Memorandum ABP-314501 – Request for Further Information

Re: South Dublin Street and Backlands Regeneration Project. The proposed

Date: 10th February 2023

SCALE: H 1:500,V 1:500. DATUM: 52.000

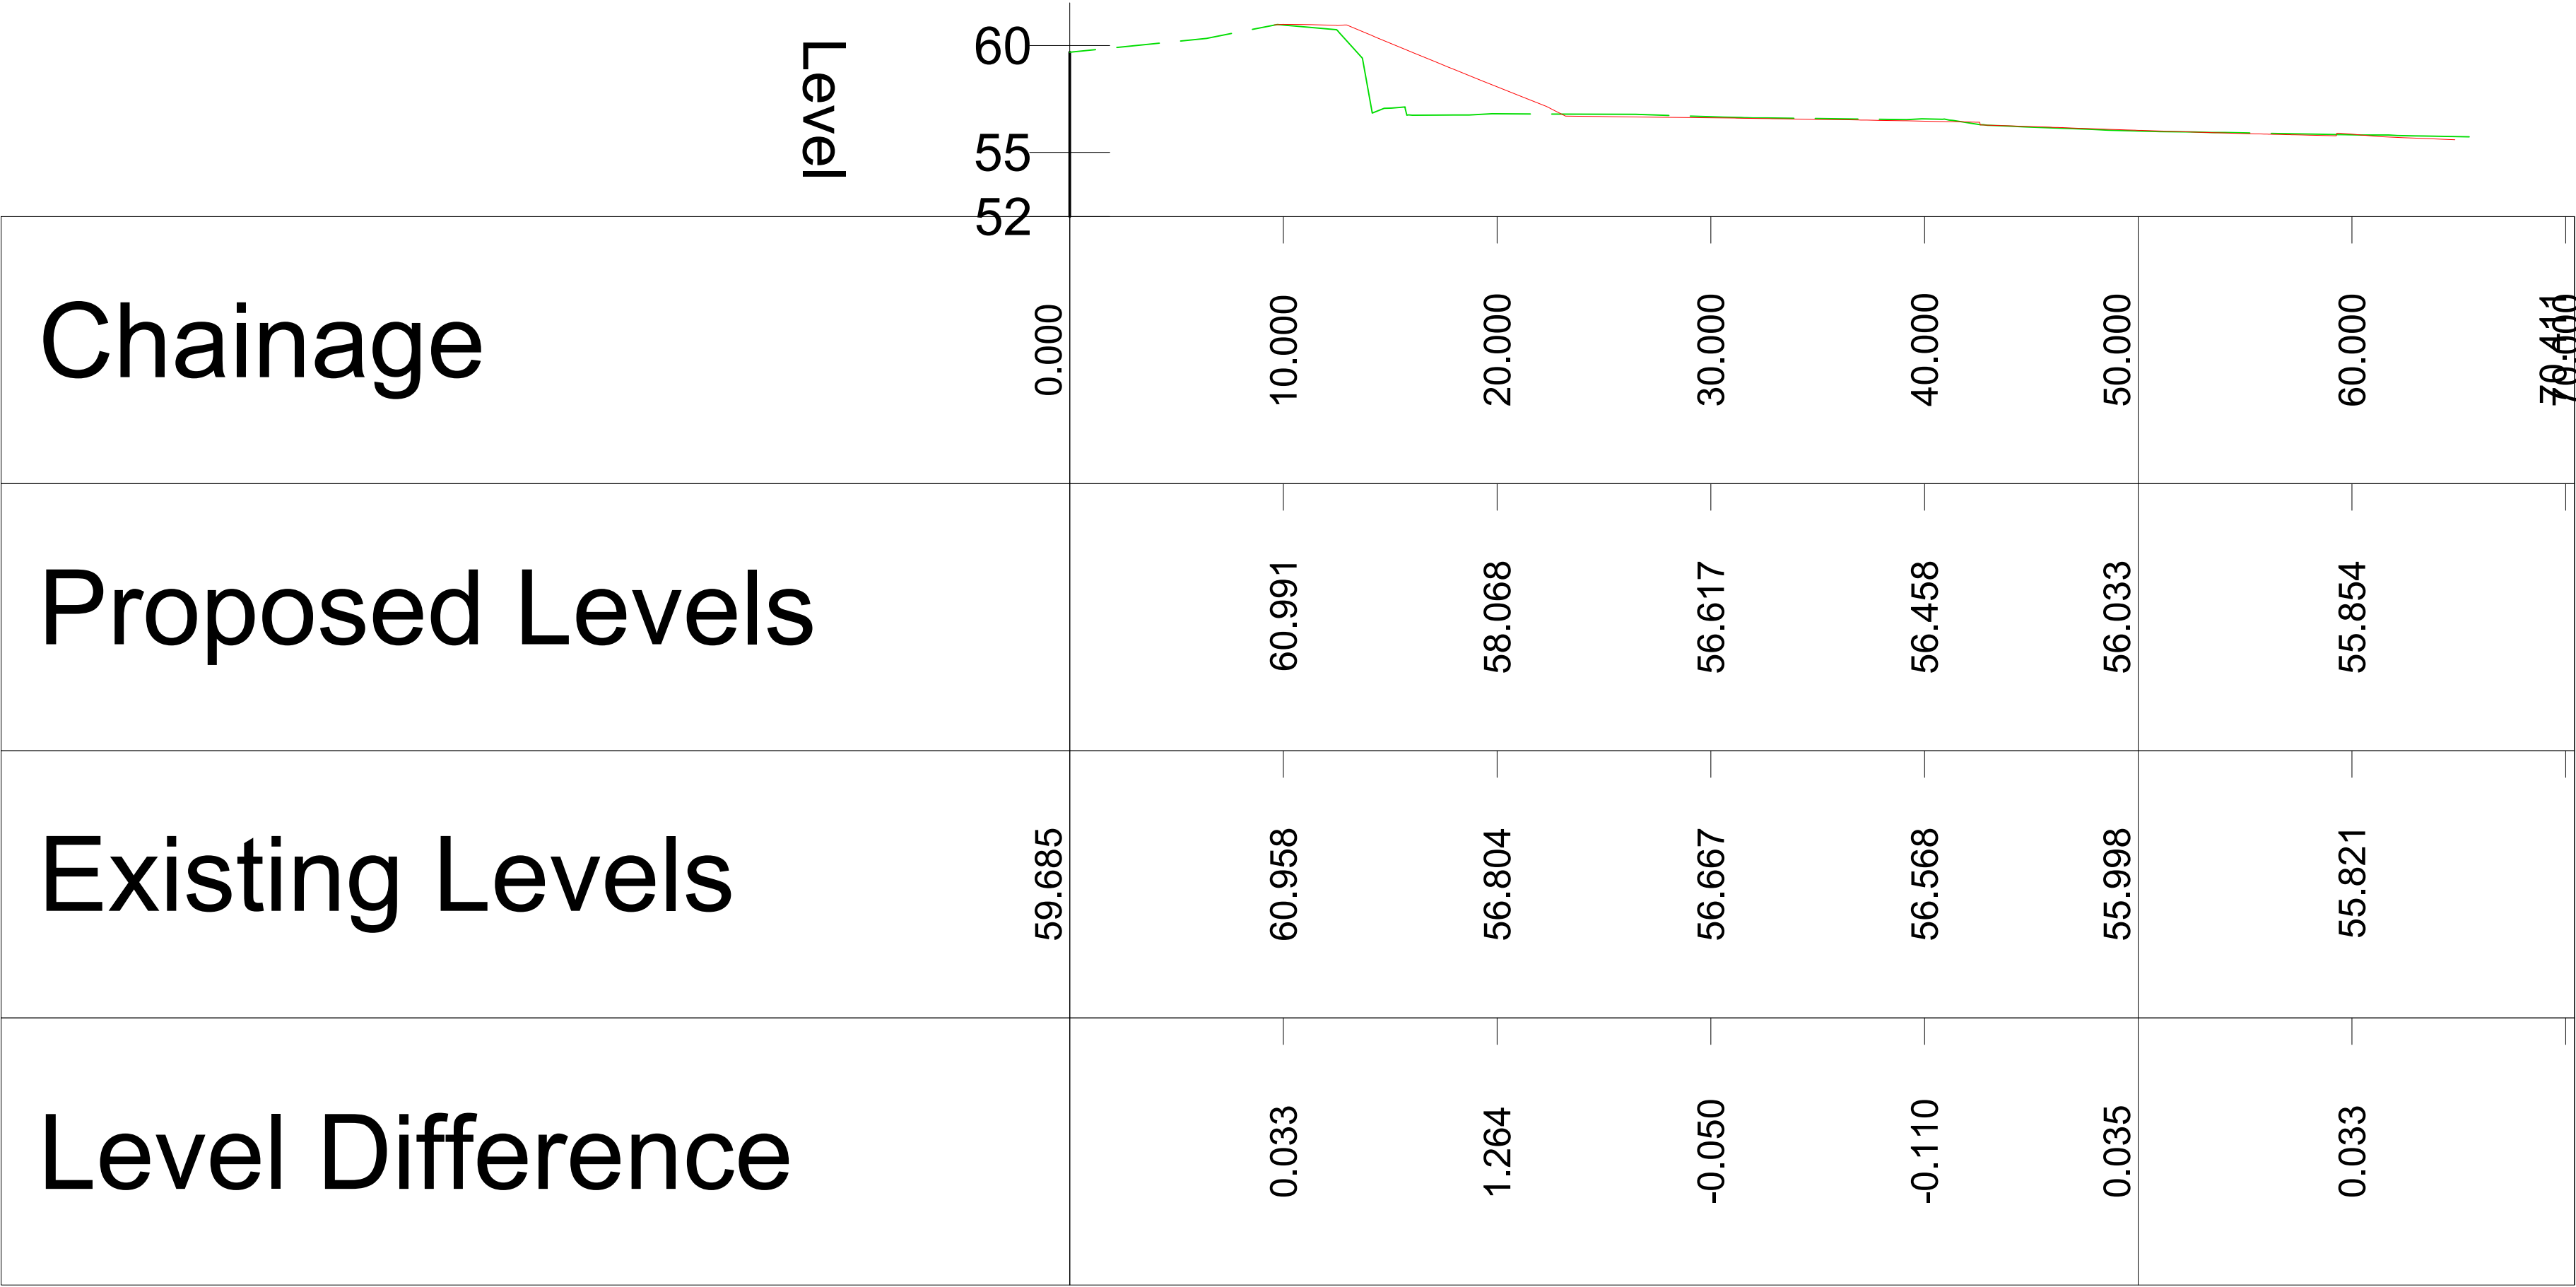
In the interests of clarity, please provide a comparison between the existing volume of attenuation and rate of discharge to the Shambles River and that proposed. Please also indicate how you have had regard to climate change in the flood risk assessment and infrastructure requirements. You are further requested to submit a cross section through the site and indicating the proposed attenuation area.

**MGT0528-
RPS-00-XX-
DR-C-DR1001
- Drainage
(Planning Issue)**

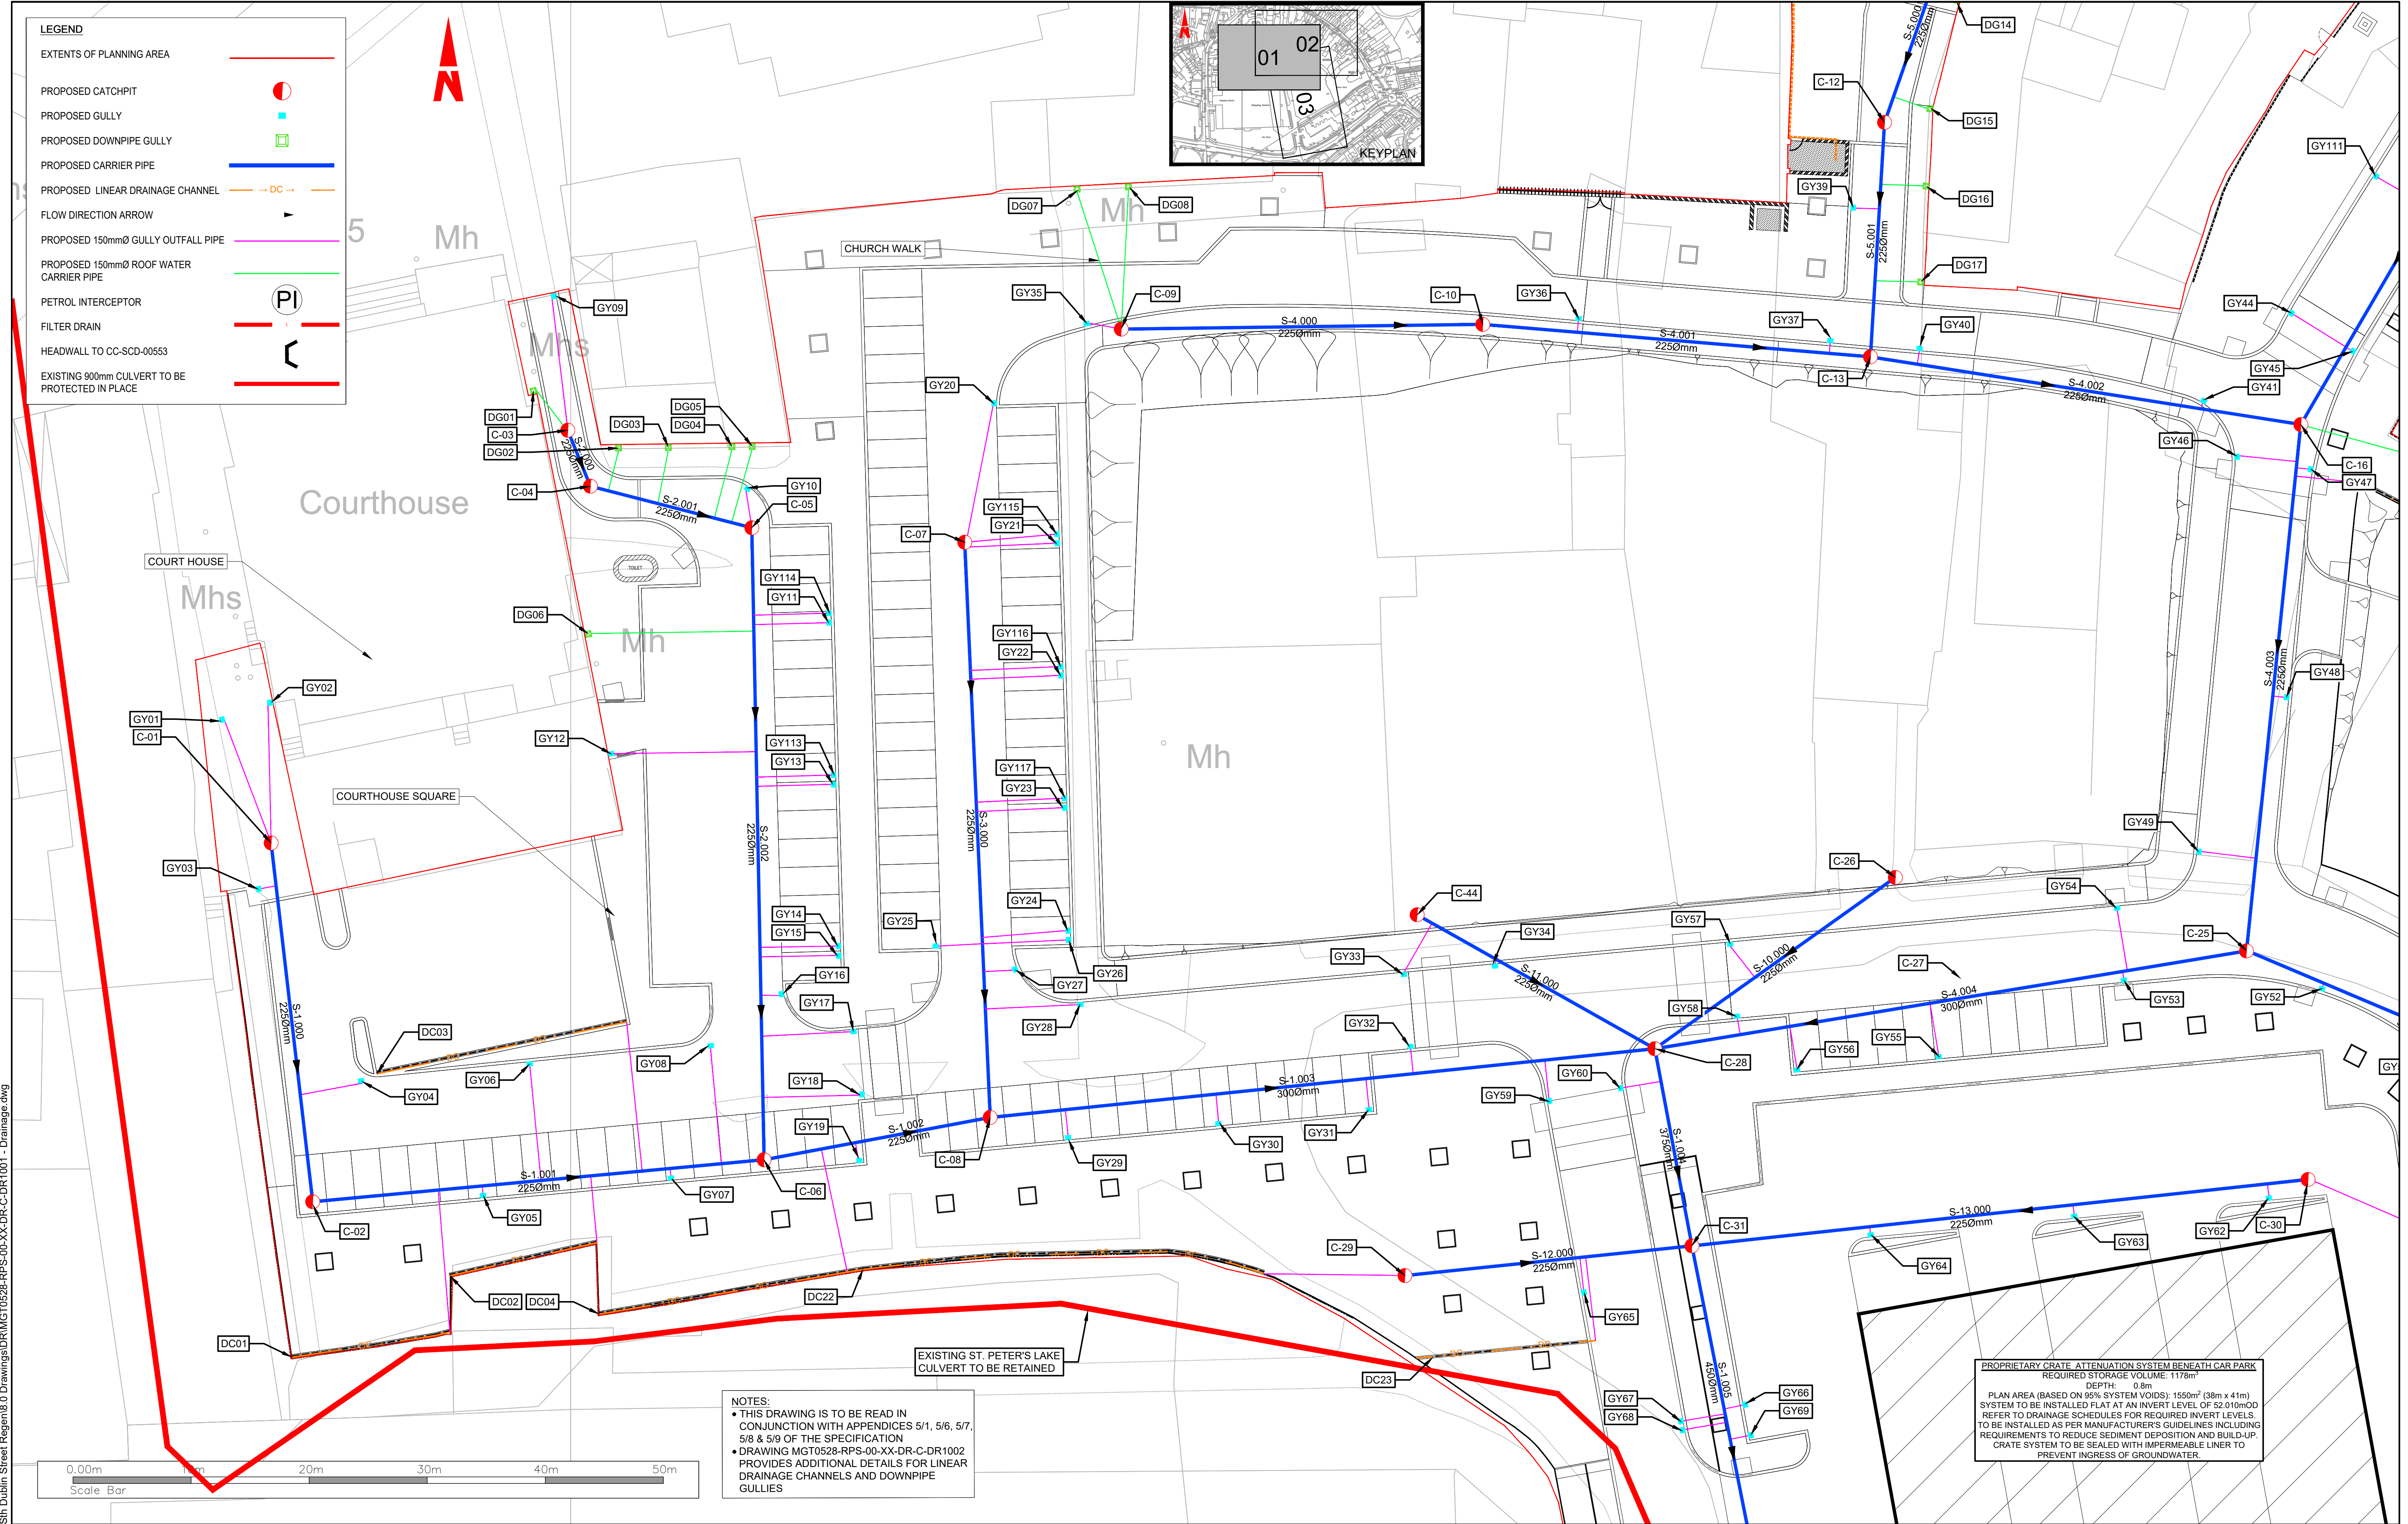
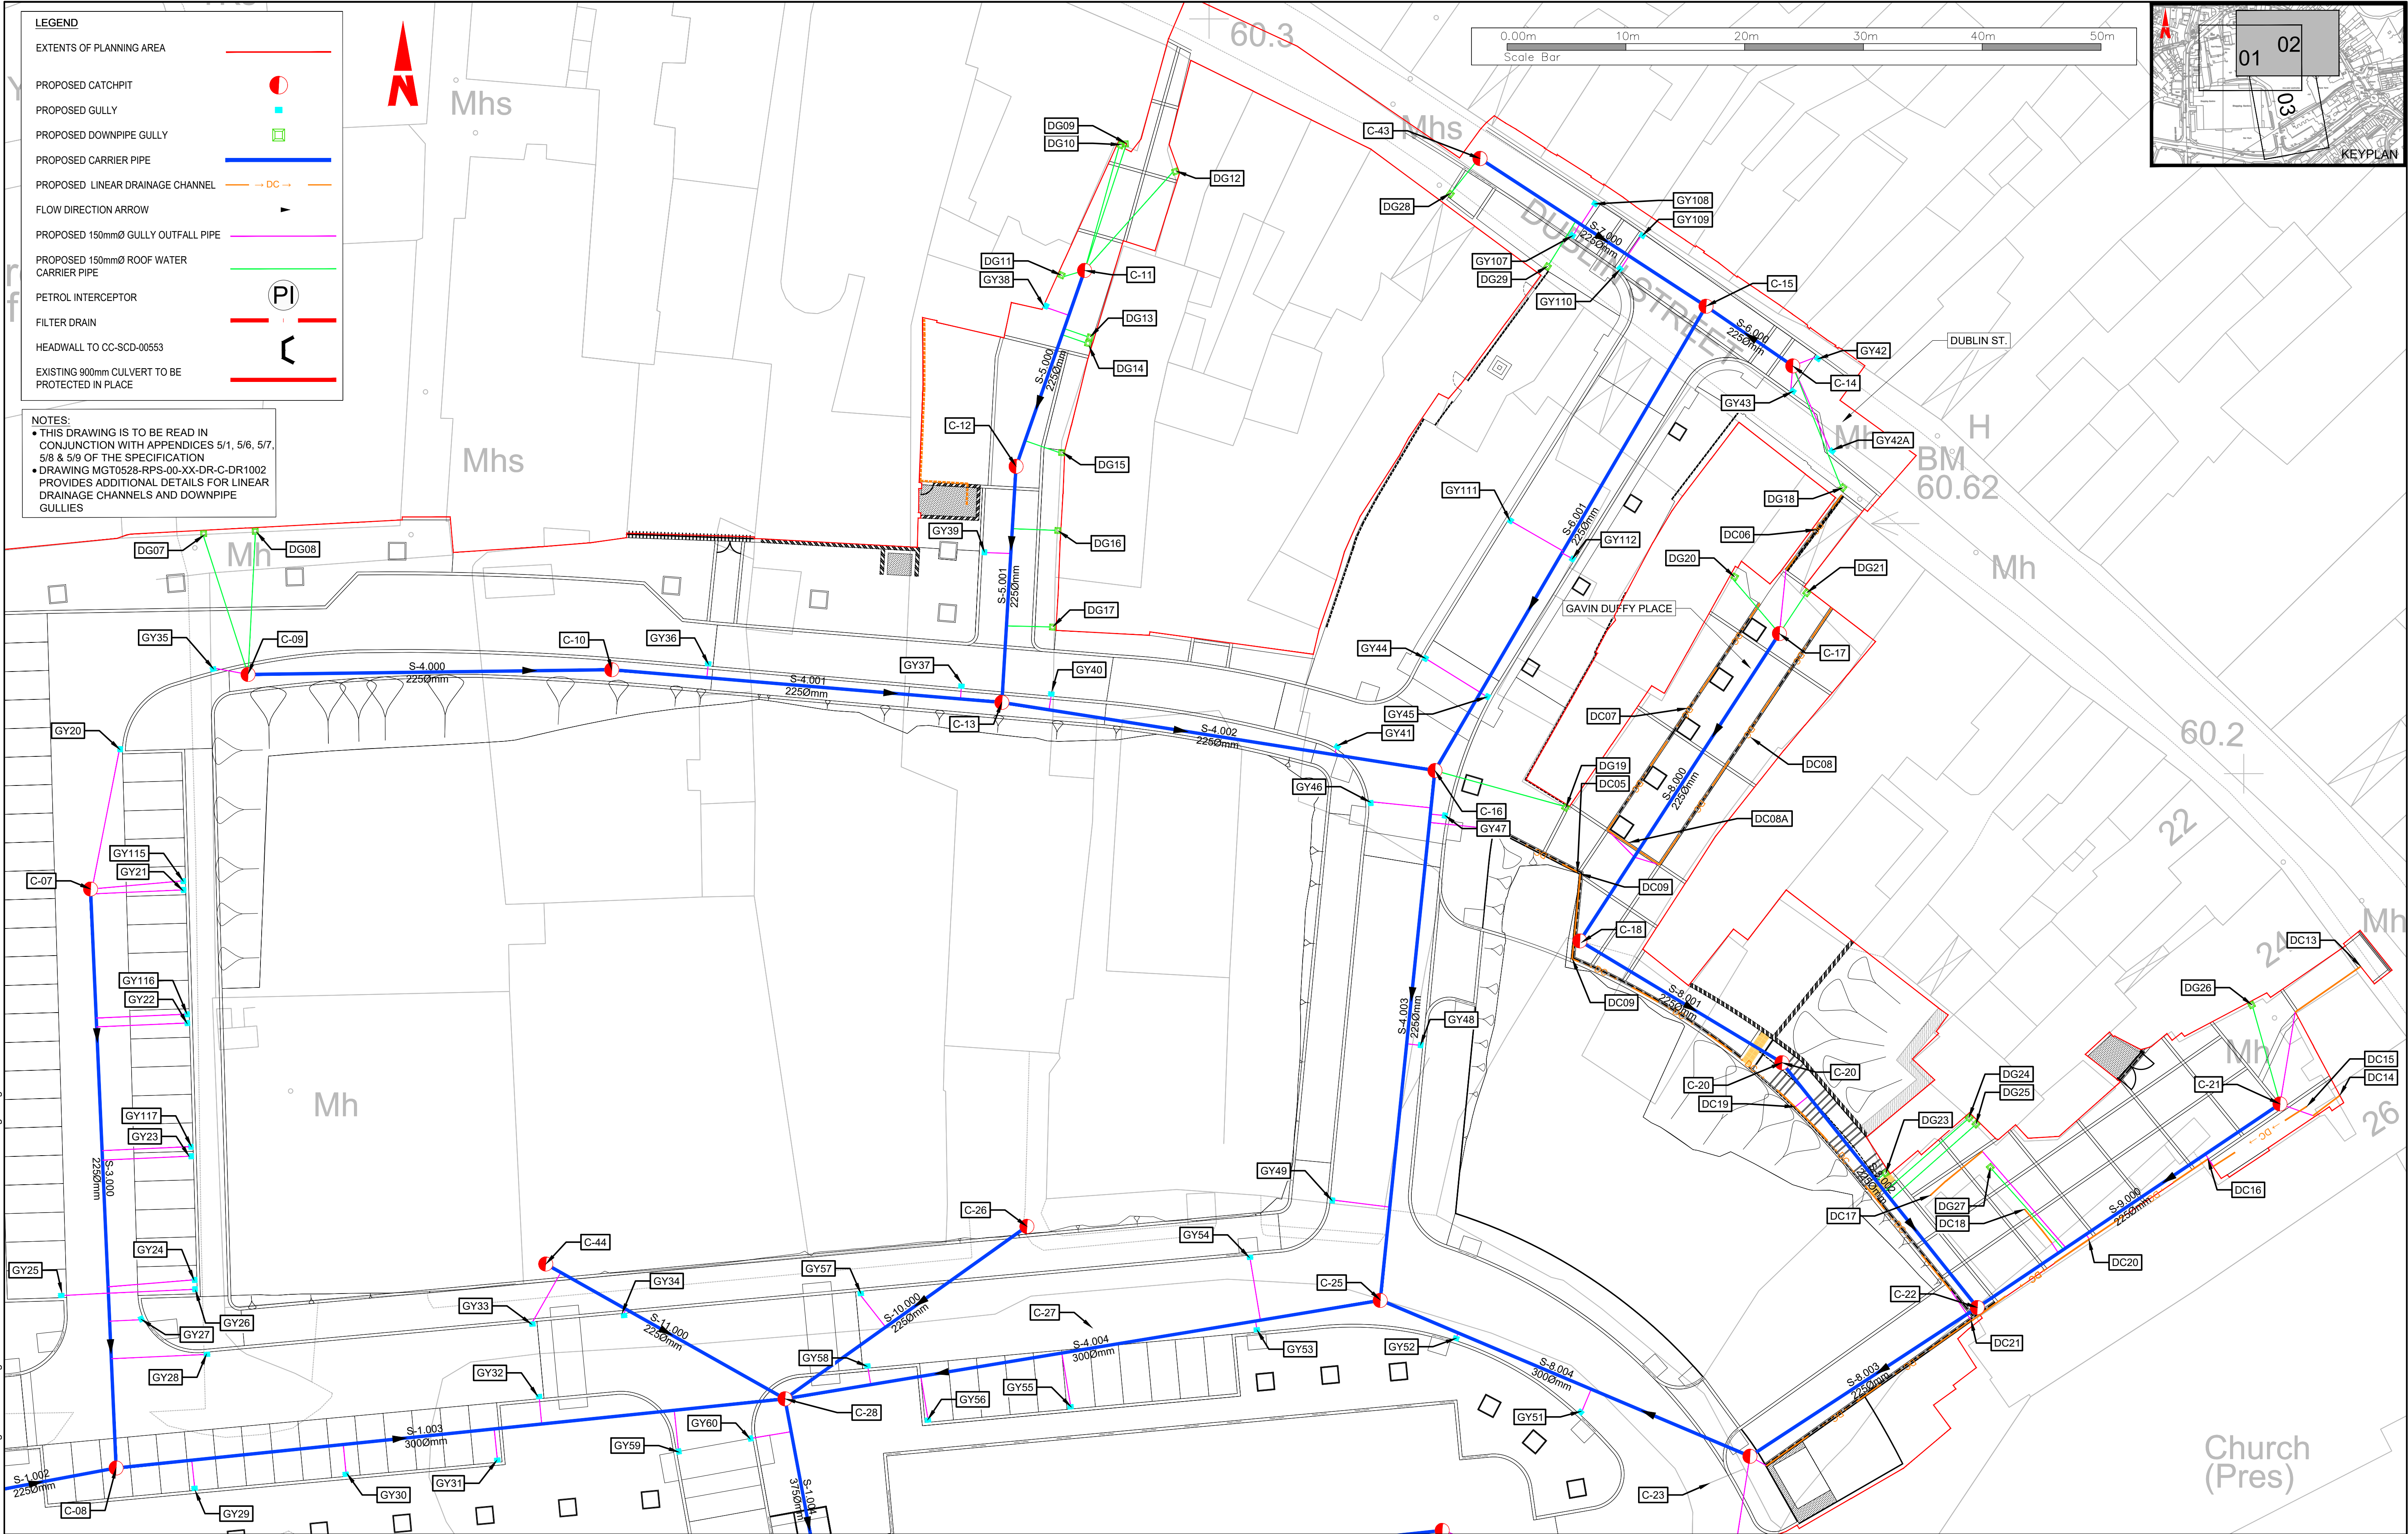
- a) Table 6.8 is a repeat of Table 6.9: summary of Ortho-Phosphate. Please submit the correct Table 6.8 Summary of Total Oxidised Nitrogen, and include a statement as to whether or not the levels are indicative of high or good quality or otherwise.
- b) The Drainage Layout Map, drawing no. DR1001 does not indicate the proposed water or sewerage network. Please submit a site layout plan detailing these proposed networks.
- c) Submit a site layout plan indicating existing service networks in the site, to include water and sewerage.
